# MORGAN AND MORECAMBE OFFSHORE WIND FARMS: TRANSMISSION ASSETS

Works Plans - Onshore and Offshore – Part 1 of 2

7 July 2025  
Rev: F03

PINS Reference: EN020028  
APFP Regulations: 5(2)(j)  
Document reference: B7/F03

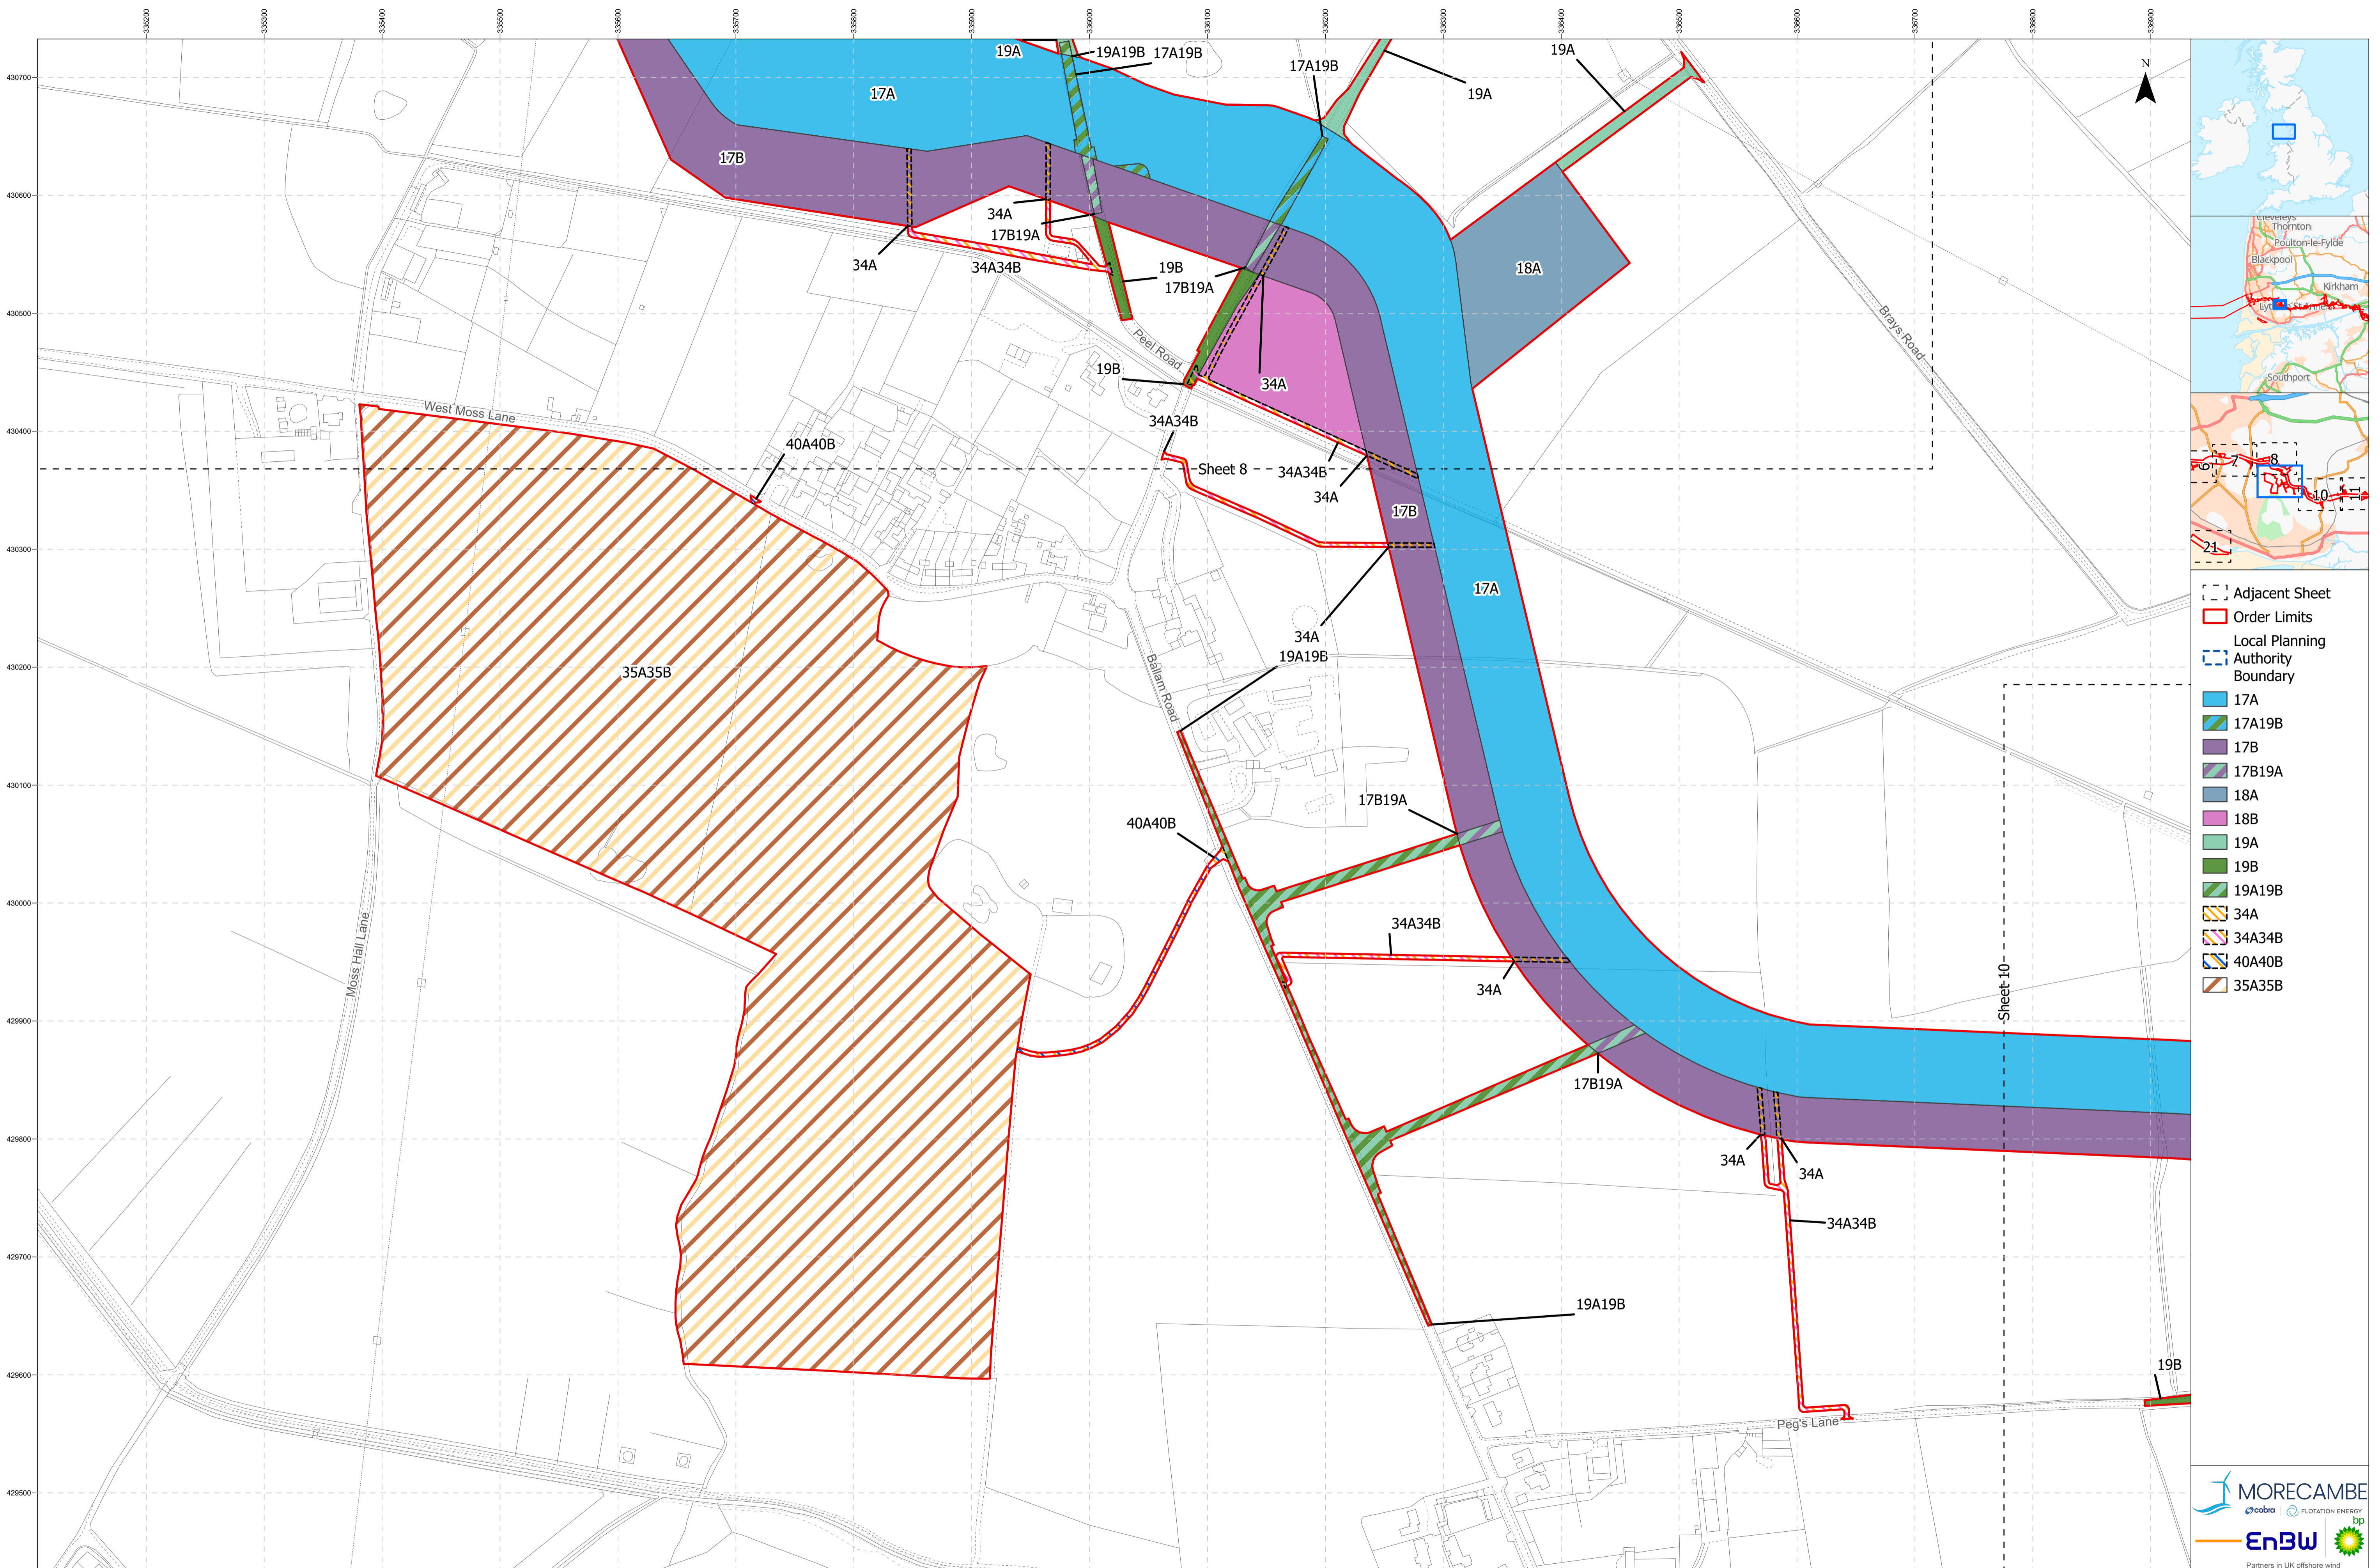
10	The Applicants	Construction access to environmental mitigation works (Work No. 40A40B) has been removed, south of Cartmell Lane.	A review of the works plans identified that construction access to environmental mitigation works (Work No. 40A40B) was not required at this location.	F02	S51 advice update
11	The Applicants	Morgan construction and permanent access to environmental mitigation works (Work No. 40A41A) has been remove off Cartmell Lane.	A review of the works plans identified that construction and permanent access to environmental mitigation works (Work No. 40A41A) was not required at this location.	F02	S51 advice update
11	The Applicants	Permanent access (Work No. 34A34B) off Wrea Brook Lane has been removed.	A review of the works plans identified that permanent access (Work No. 34A34B) was not required at this location.	F02	S51 advice update

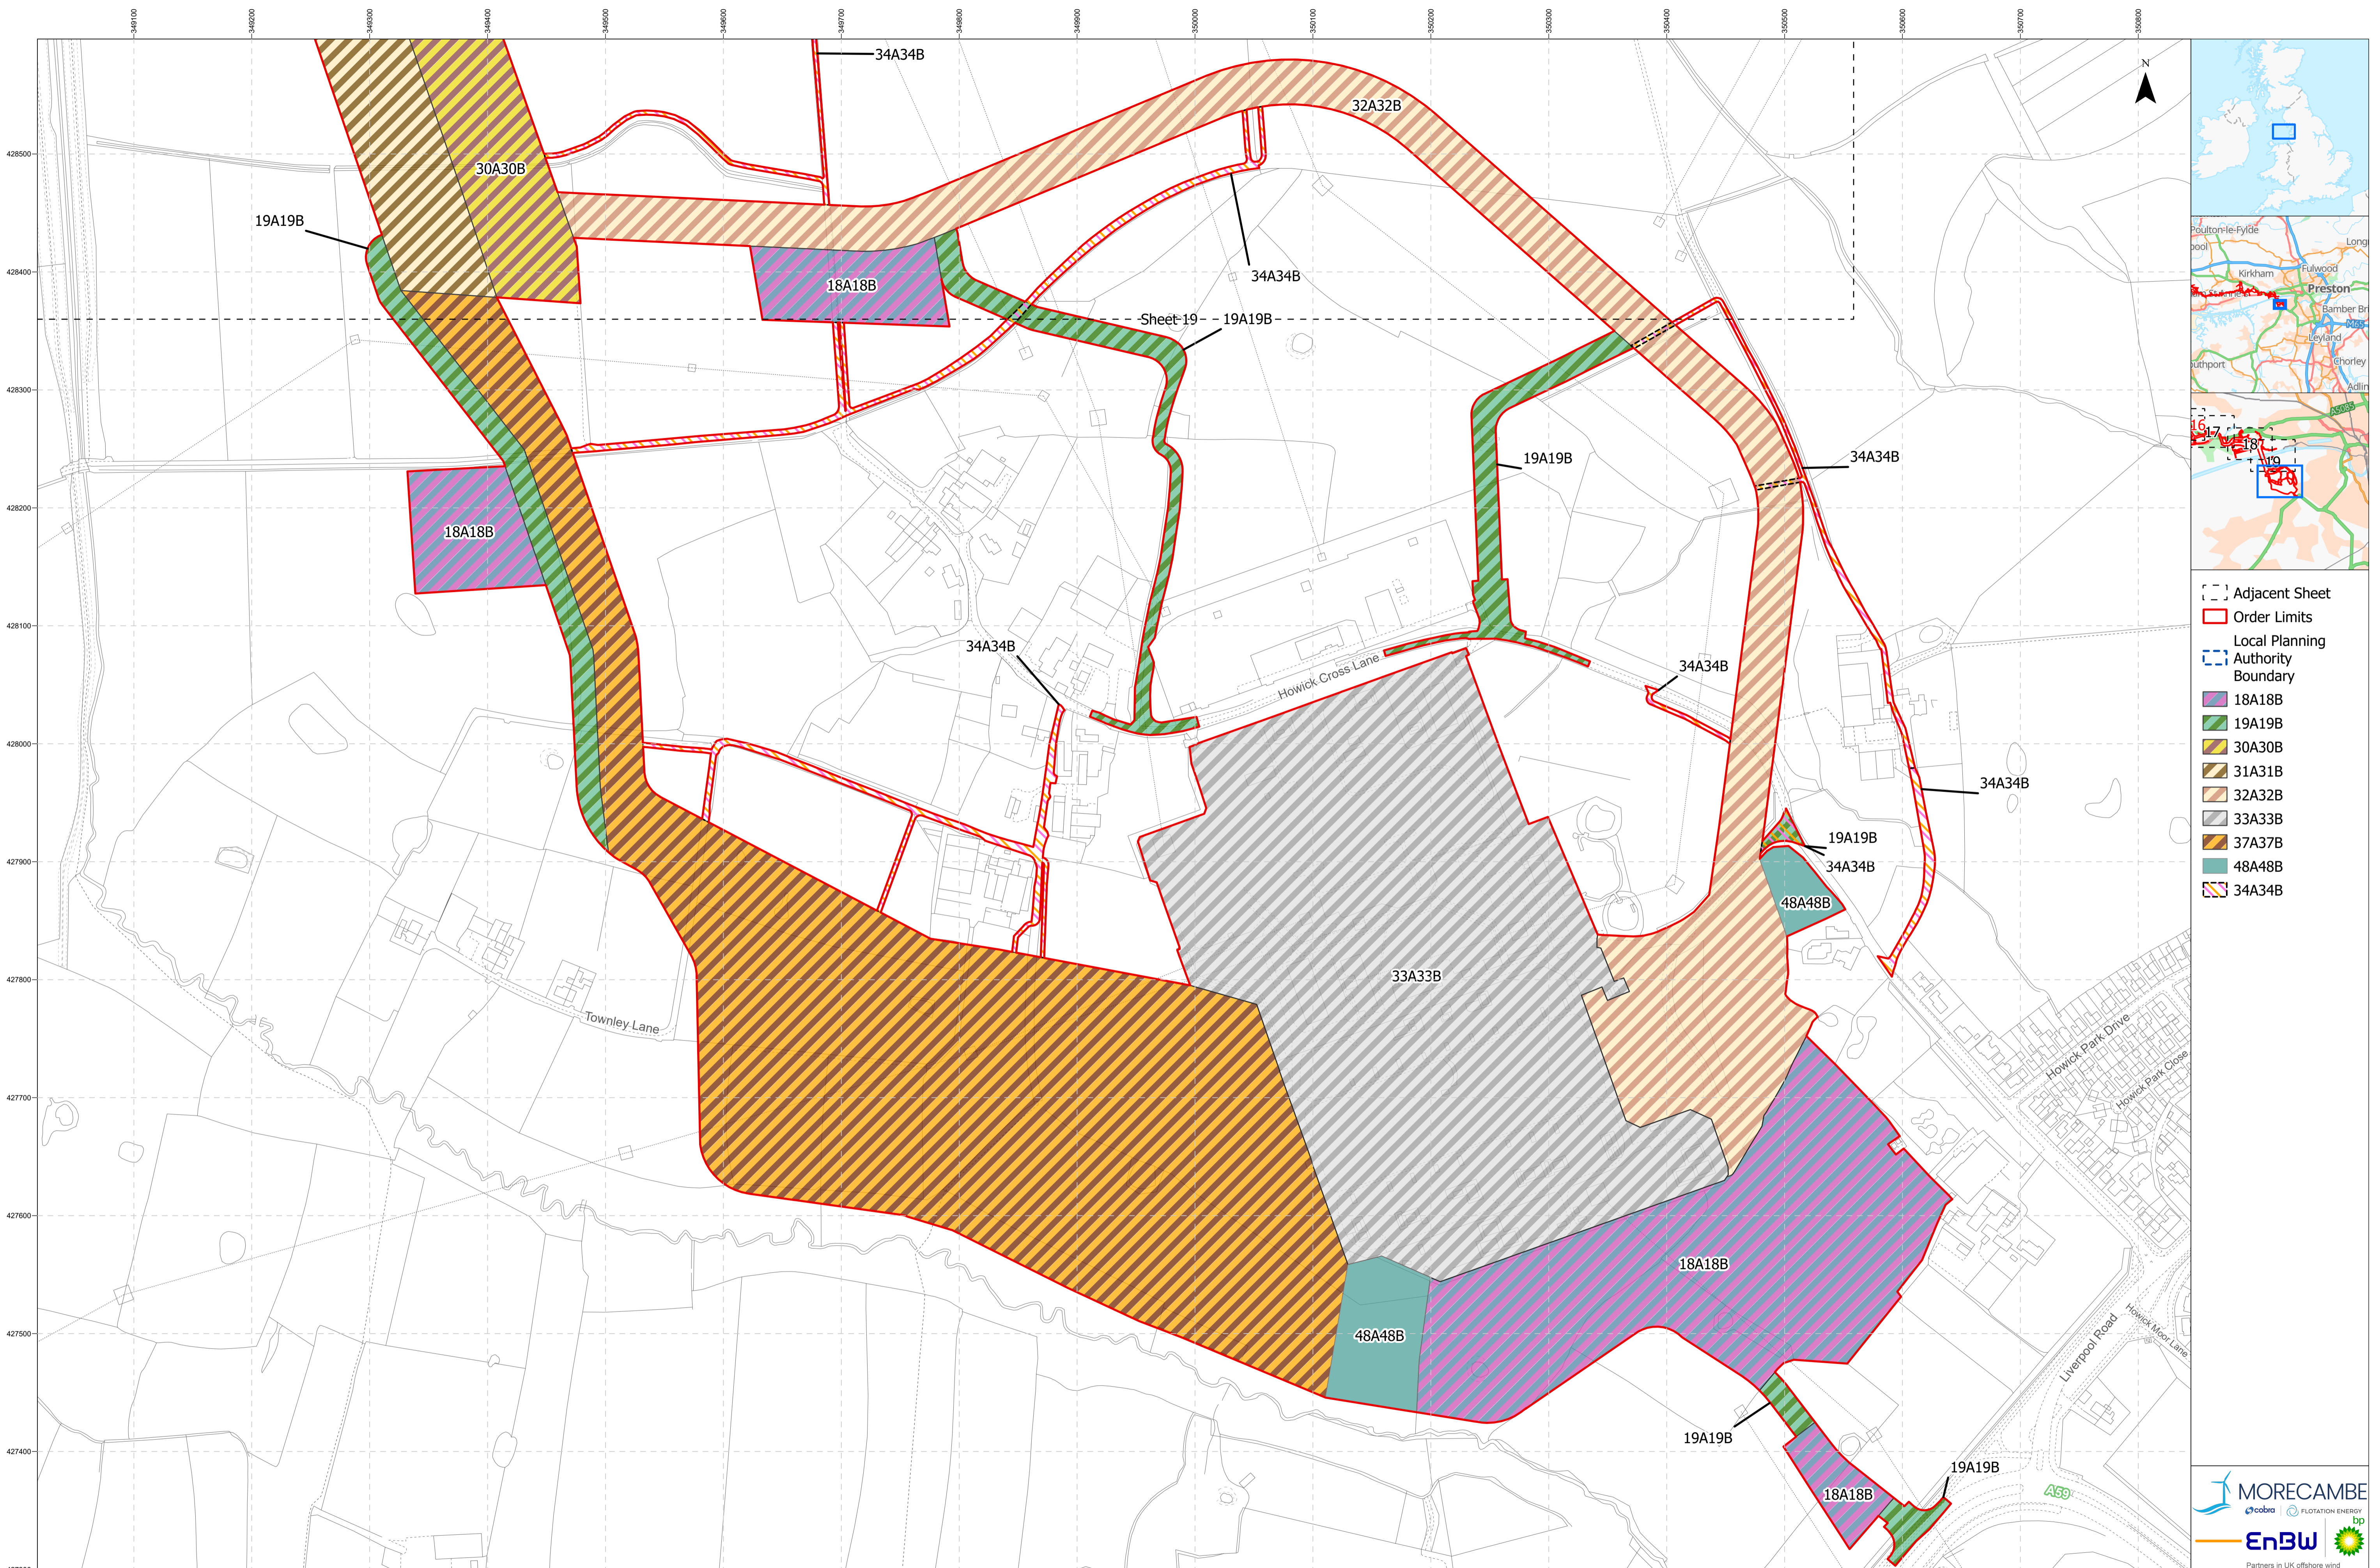
Sheet Number	Change requested by	Change Made	Reason for Change	Revision	Submission deadline
19	The Applicants	The Morecambe construction access (Works No. 19B) over the Morgan 400kV grid connection cable corridor on the northern bank of the River Ribble (Works No.25A) has been removed.	A review of the works plans identified that construction access to Work No. 25A was not required at this location.	F02	S51 advice update
19	The Applicants	The Morecambe permanent access (Works No. 34B) to the 400kV grid connection cable corridor on the northern bank of the River Ribble (Works No.25B) has been aligned with the existing pathway.	A review of the works plans identified that permanent access (Work No. 34B) was wider in one section, therefore it has been reduced to align with the existing pathway.	F02	S51 advice update
19	The Applicants	The permanent access (Work No. 34A34B) to the Morgan and Morecambe 400kV grid connection cable corridor on the northern bank of the River Ribble (Works No. 25A and 25B) has been refined.	A review of the works plans identified the need for the permanent access (Works No. 34A34B) to be refined, to ensure that the permanent access allows both projects to access their respective cable corridors.	F02	S51 advice update

19	The Applicants	Permanent access (Works No. 34A34B) has been extended over Works No. 30A30B to ensure access to the 400kV grid connection cable corridor on the southern bank of the River Ribble (Works No. 31A31B)	A review of the works plans identified that permanent access (Work No. 34A34B) to the 400kV Grid Connection Corridor (Work No. 30A30B) was previously omitted.	F02	S51 advice update
19	The Applicants	Permanent access (Works No. 34A34B) has been extended over Works No. 32A32B and 18A18B to ensure access to the 400kV grid connection cable corridor on the southern bank of the River Ribble.	A review of the works plans identified that permanent access (Work No. 34A34B) to the 400kV Grid Connection Corridor (Work No. 30A30B and 29A29B) was previously omitted.	F02	S51 advice update
